Alternative Design Review

97 Cumberland Avenue

Design Review by Caitlin Cameron, Jean Fraser, and Alex Jaegerman

5/22/14

A3.1

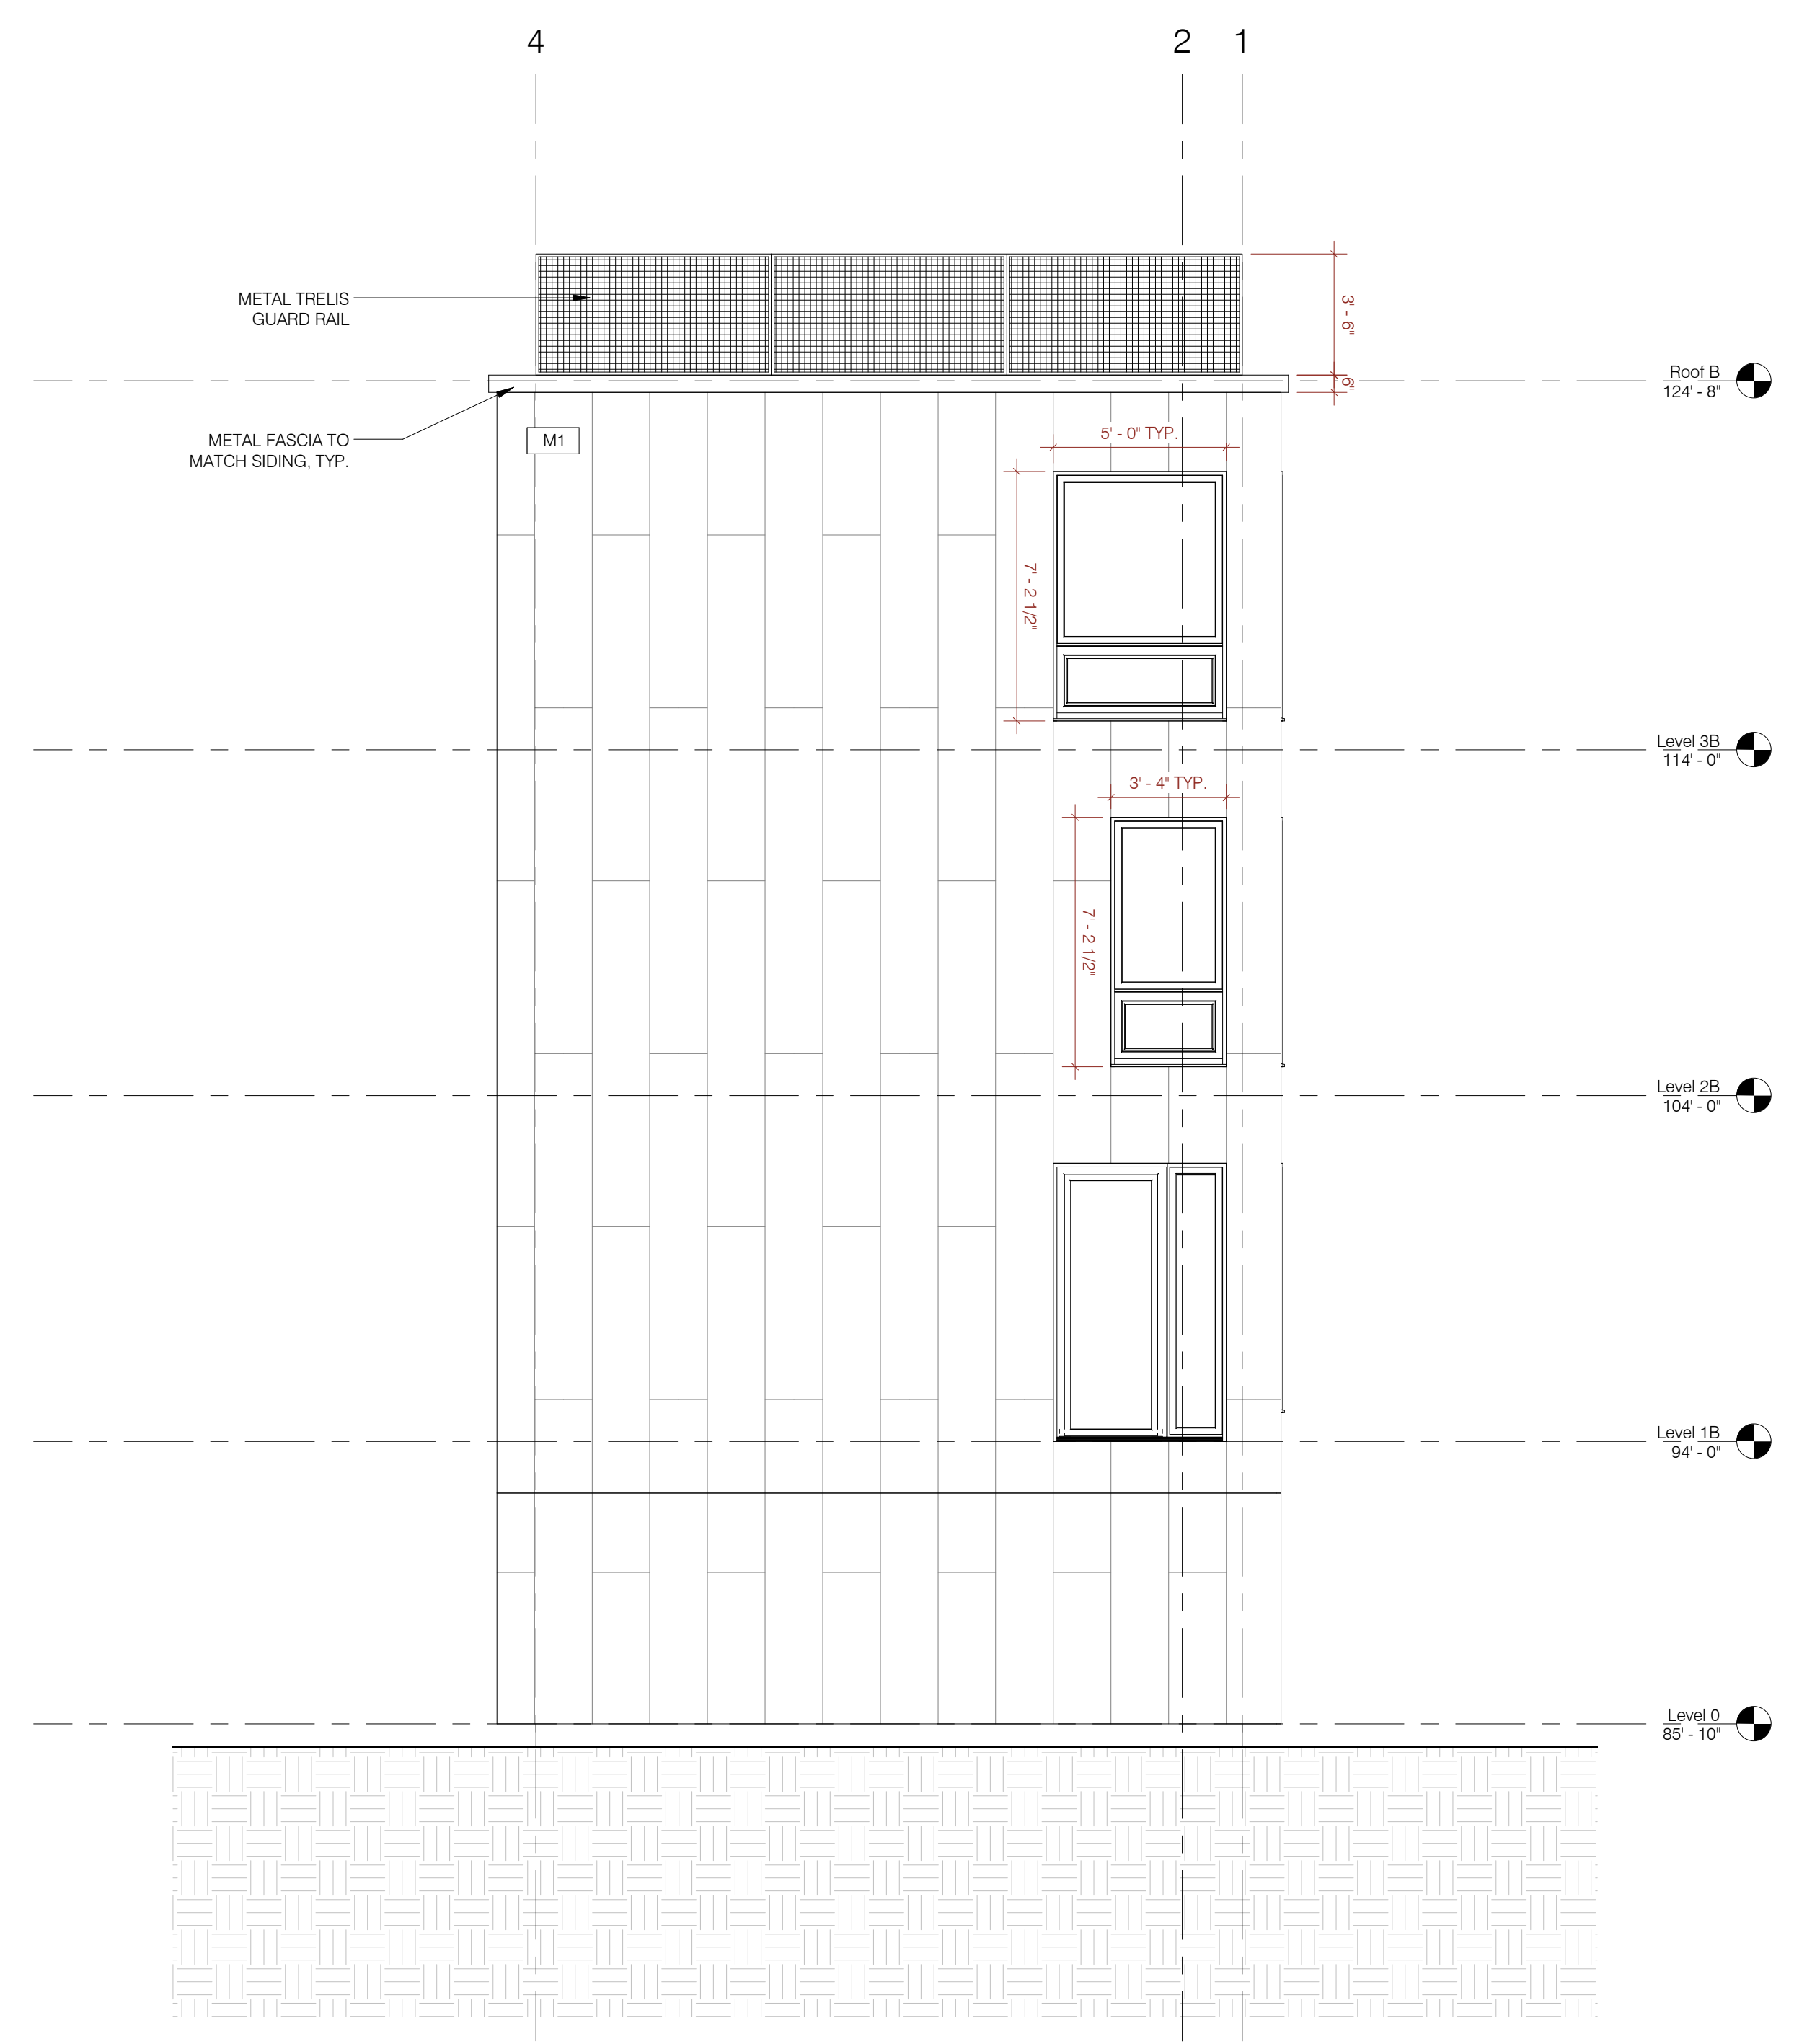
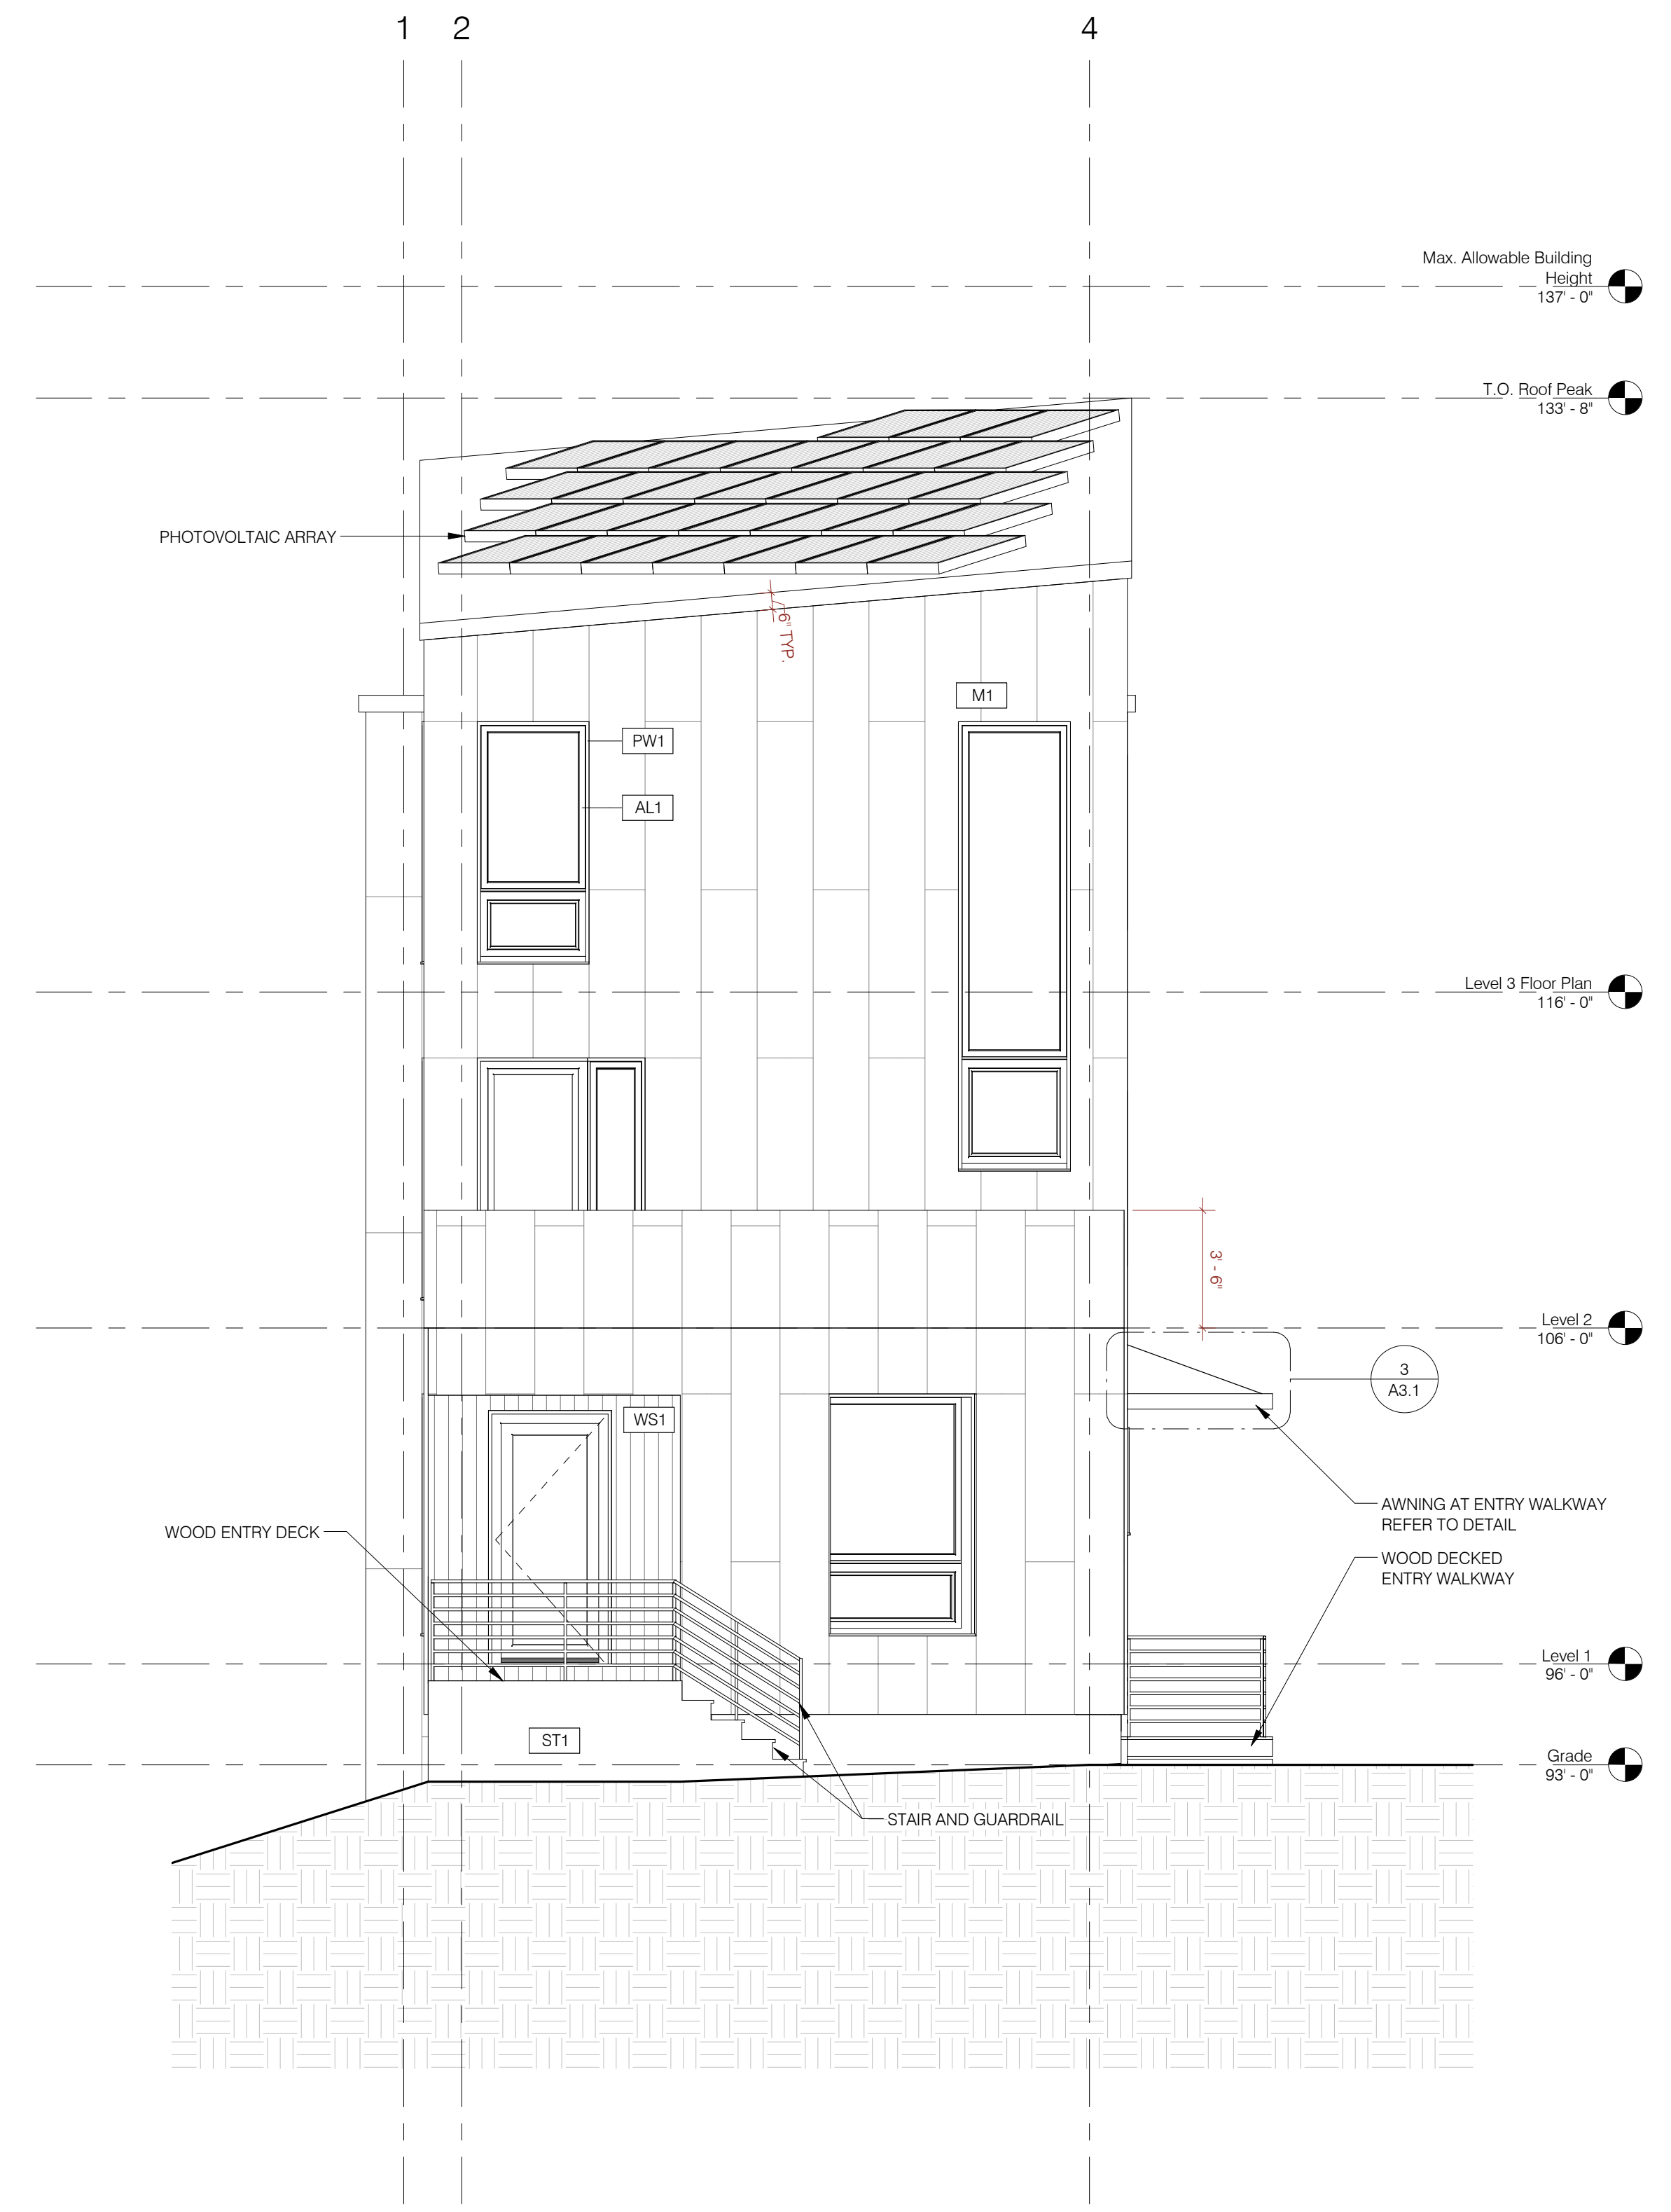
- d. Proportion and Scale: The project maintains the proportions and scale found in the surrounding buildings with a three-story façade. Front and side entries are covered and provide human-scale elements. The front façade is further broken up into two forms, the projecting form nearest the street is one-story tall.

- e. Balance: The façade composition is balanced employing local symmetries with an appropriate and pleasing proportion of window openings to solid façade.

- f. Articulation: The building design is successful in creating a visually interesting and well-composed façade on Cumberland Avenue as well as towards Washington Avenue with the use of covered porches, window types, emphasized entries, and detailing such as green screen and window reveals.

- g. Materials: Although the project uses a material unique to the context, the design reviewers found the material to be harmonious in color, texture, and authenticity with the neighborhood material palette which tends towards red brick industrial/commercial buildings and brick-based and clapboard-sided residential. The red finish of the metal compliments the depth, texture, and color of brick while the use of planks provides a rhythm on the façade similar to clapboards.

- The majority of Standards within each Principle are met.
- On the topic of massing, the roof form of the proposal is unique to the neighborhood and deviates from two standards to do with roof forms and roof pitch. However, four of the six standards within that principle were met and therefore the deviation in roof

forms is allowed by the Alternative Design Review. In this case, the roof forms proposed are integral to the function of the solar array.

- On the topic of articulation, this project does not use the same type of detailing found in the context (pronounced cornices, railings, eaves and rakes), however, the design does meet the intent of the standards according to its own aesthetic language incorporating articulation with window reveals, cohesive window types, porches/decks, and an emphasized main entry; the result maintains a visual cohesion.
- On the topic of materials, the proposed exterior material is a metal panel cladding in a rust-red finish. While the material is unique to this neighborhood, the reviewers felt the color, texture, and use of the proposed material is harmonious with the surrounding material palette. The standards call for the materials to be harmonious, not identical, and to be used in an authentic way.

- a. Scale and Form: The project must mediate between the scale and form of the residential buildings (mostly two and three-story single family with gable roofs and triple-decker with flat roofs) as well as the industrial and commercial scale and forms of Washington Avenue. The Cumberland Avenue façade maintains the width and height of the surrounding residential buildings. The façade visible from Washington Avenue is broader and in keeping with the larger scale of that corridor.

- b. Composition of Principal Facades: The principle façade on Cumberland Avenue keeps the local symmetry of the main entry similar to the houses surrounding it with a covered porch. Where this project differs from its neighbors is the further setback of the full height of the building.
